Consultation Response from KC, Lead Local Flood Authority
2025/90708 Land at, Merchant Fields Farm, off Hunsworth Lane, Cleckheaton
Discharge of details reserved by conditions 3 (Construction (Environmental) Management Plan), 6 (Temporary surface water management details), 8 (Proposed internal adoptable roads), 9 (Permanent site entrance details), 16 (Surface water attenuation details), 17 (Details of Swale/ditch management), 19 (Phase II Site Investigation details), 20 (Remediation Strategy), 25 (Noise Impact Assessment), 30 (Arboricultural Method Statement/ Tree Protection Plan), 34 (Biodiversity Gain Plan) of permission 2024/91260 for Variation of conditions 2 (plans and specifications) and 35 (removal of permitted development rights) on previous permission 2021/92801 for erection of 291 dwellings with associated works and access from Hunsworth Lane and Kilroyd Drive – revisions to house types, unit size mix and layout

Date Responded: 15th August 2025 Responding Officer: Paul Farndale Responding Ref:

Condition 6 – Construction Phase Flood Risk and Pollution Plan (temporary drainage).

Condition 16 – Attenuation, Flow Control and Maintenance & Management

HYDROBRAKE DETAIL
NOT TO SCALE

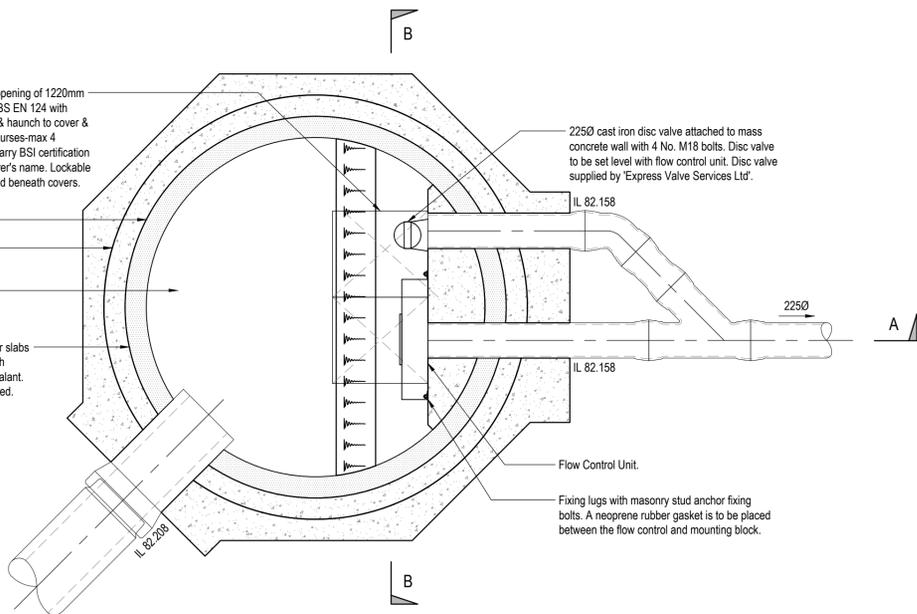
The flow control device should be included in the maintenance and management regime for SUDS, clearing sumps, penstock and bypass plate maintenance, and the replacement of the neoprene seal if the flow control device is ever removed. **The replacement of neoprene seal has been omitted for phase 1. Please ensure all the above in incorporated.**

A flow control for the western drainage system has a 73mm orifice. The absolute minimum required of 75mm with a preference for 100mm to prevent blockages. The design must be revisited. **As stated above, this is unacceptable for phase 1.**

APPENDIX 1

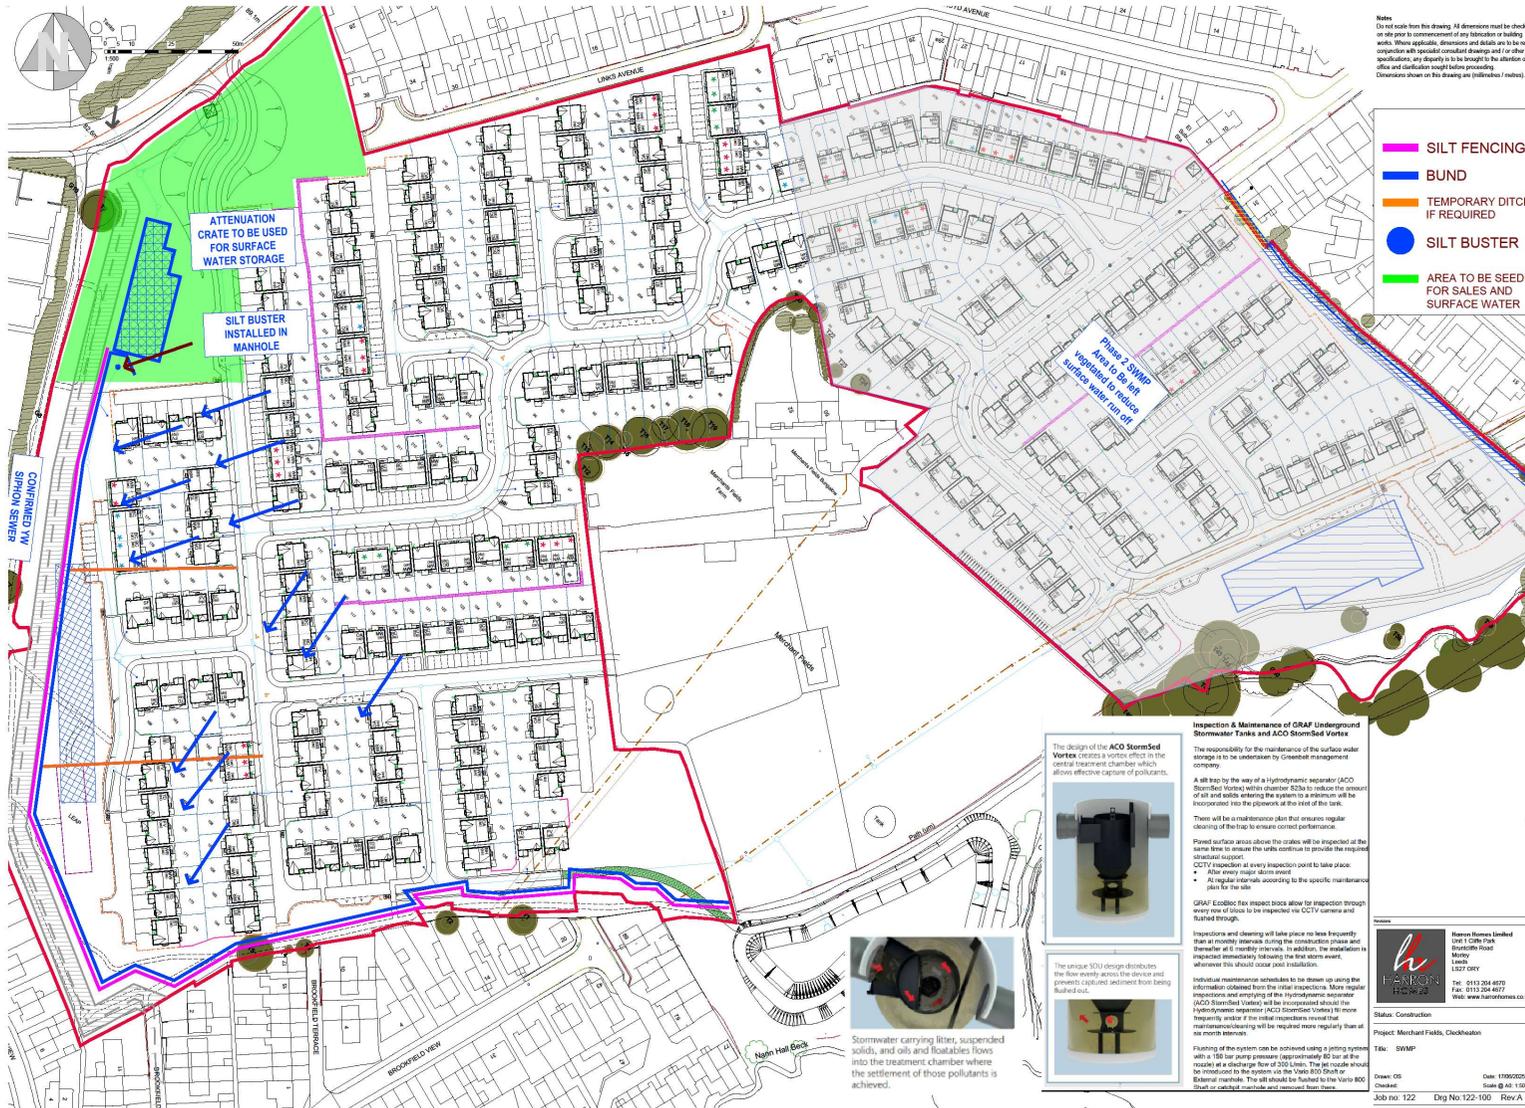
A narrative has been supplied but drawings still show one phase. At the very least pre and post attenuation installation phases are required. However, in this case some land is not to be soil stripped straight away so such phases should be detailed in description and plan. **Plans will be considered for phase 1 with details on phase 2 to come so that the condition can be considered for each phase in isolation.**

We also believe water stored by bunds is likely to require sediment to settle out before discharging to watercourse. A tanker should be the last resort. Klargesters or similar are often used as a back up where dealing with sediment proves to be an issue. **Methodology of silt removal has been promoted with back of plans where this proves inadequate.**

It is not clear from levels of bunds and topography where the 1 in 2 6 hours storm will site on site. This capability needs to be shown and this space's place in the development programme considered. **Prior to full drainage infrastructure going in, run off will still move away from any attenuation tank installed. Despite bunds being shown, that areas to store water do not appear to make sense as the contours are different and water will be conveyed to a low spot. A 1 in 2 6 hours event was discussed with Harron Homes, this does NOT appear to have been considered in the latest submissions.**
